CITY OF ALBUQUERQUE

**RE: DaVita Dialysis Center, 5207 San Mateo Blvd.
Grading and Drainage Plan
Plan Dated 4-20-15 for Sheets C2.0-C.2.2; Plan Dated 5-6-2015 for Sheet C5.0
(File: F17-D095A)**

Subject: **Del Norte Dialysis Center, 5207 San Mateo Blvd. NE**
Final Drainage Submittal Response
Project: F17-D095A

**C5.0**  
SHEET 9 OF 12

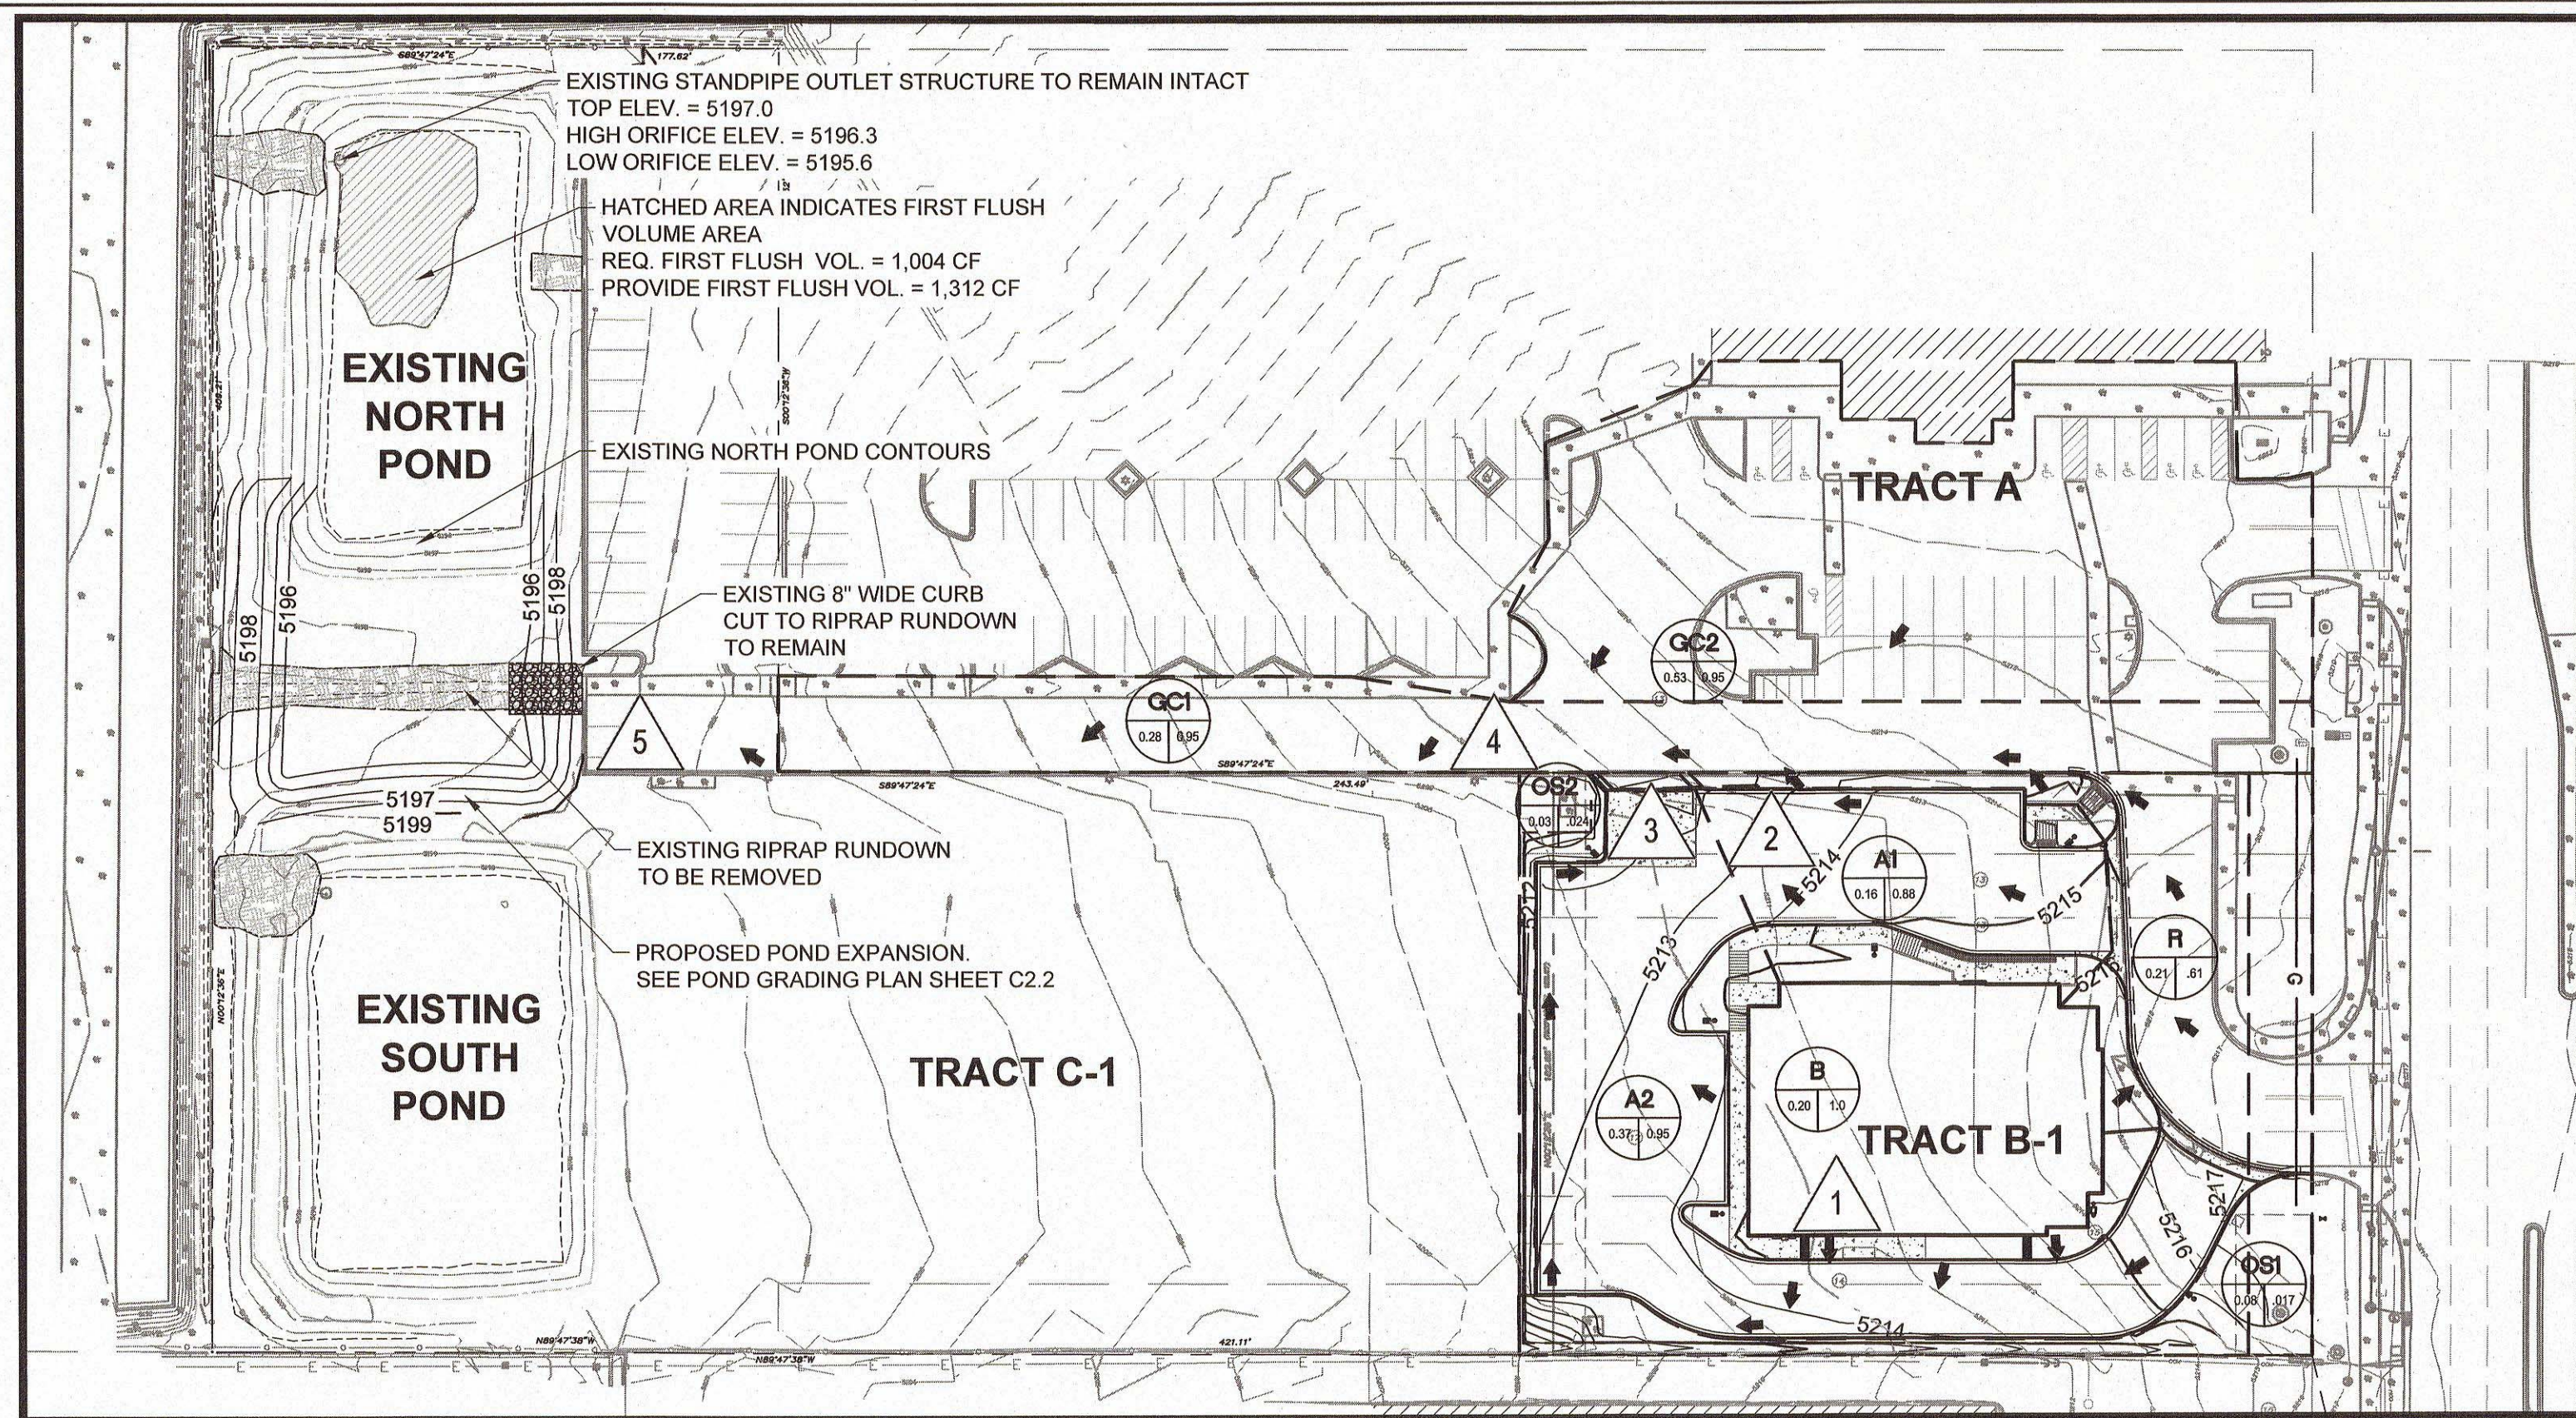
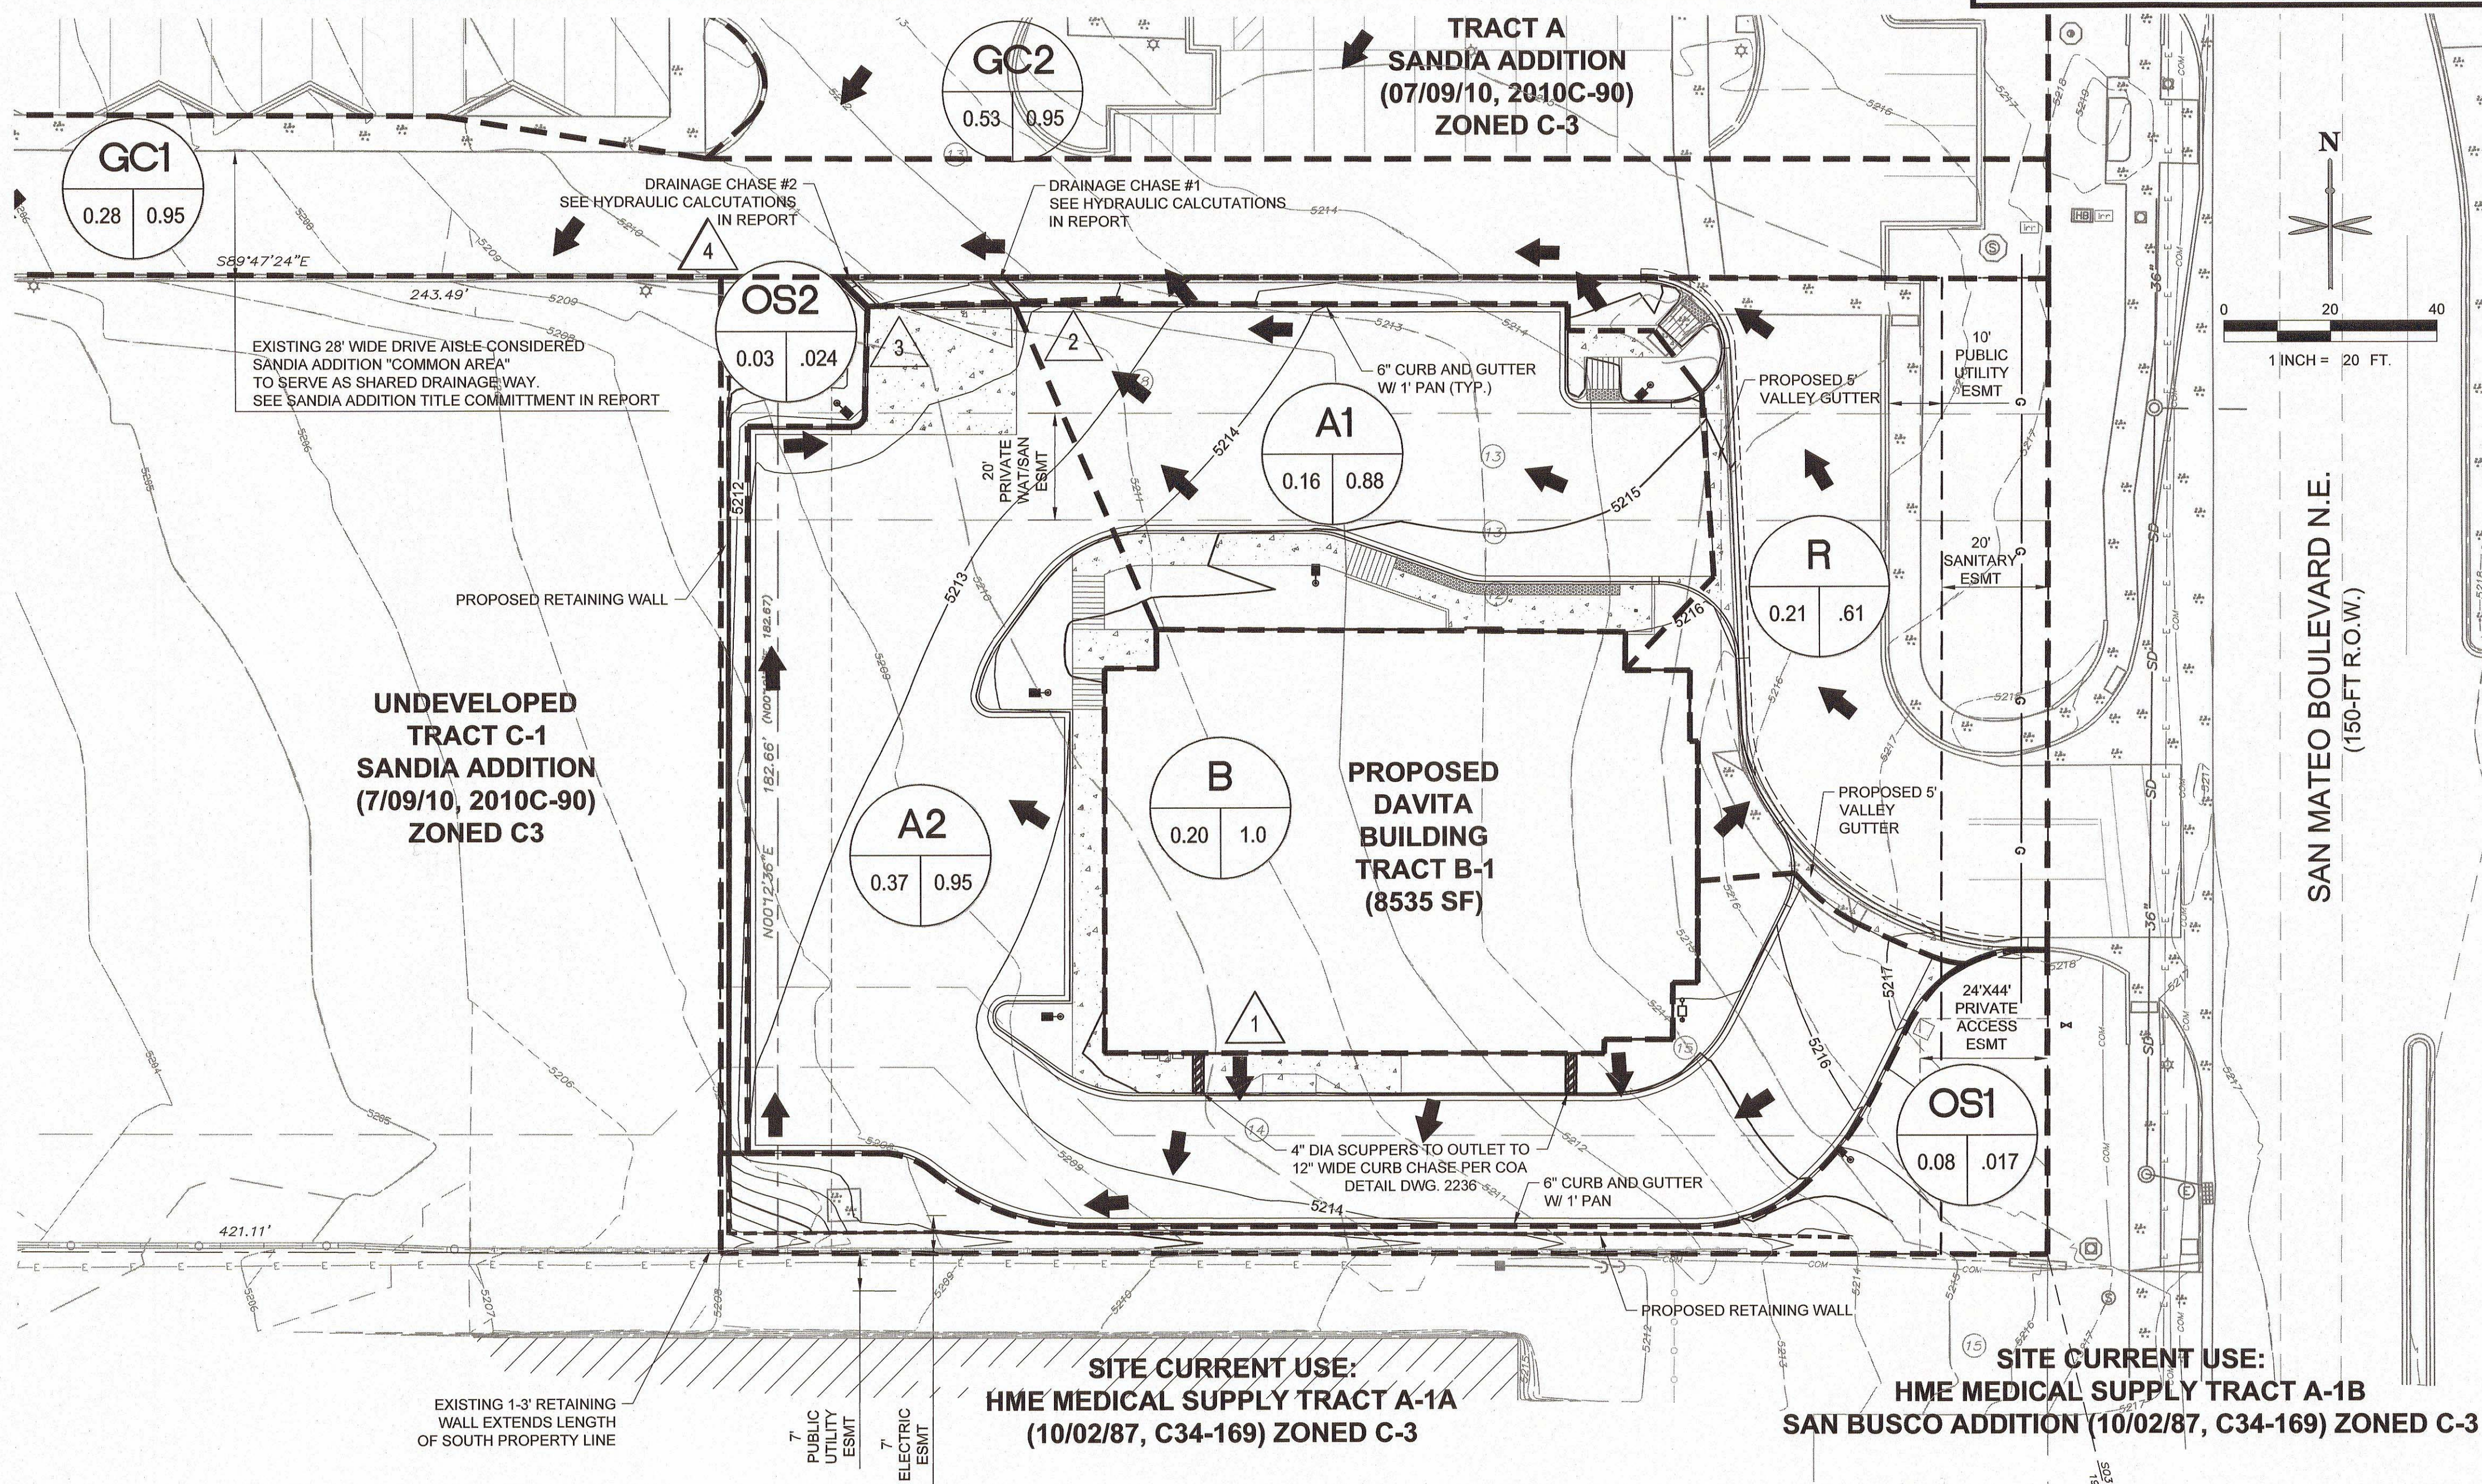
2. On the Sheet C5.0, include your computed WSEL for the 100 year storm, the total volume provided for the storage pond, and the corresponding pond volume at the WSEL.
All information as described above is now shown on Sheet C5.0 in the text box titled Overall North Pond Storage at the top of the sheet.

3. Also, on Sheet C5.0, show all basins that contribute to the north pond which shall include all off-site storm water runoff from the Golden Corral parking lot. **Done. The offsite stormwater tributary to the North Pond is shown as GC3 and this basin was recreated using the Golden Corral Drainage Plan (see report appendix for this plan). Basin GC3 incorporates Basins DA No. 12 & 13 on the Golden Corral Plan.**
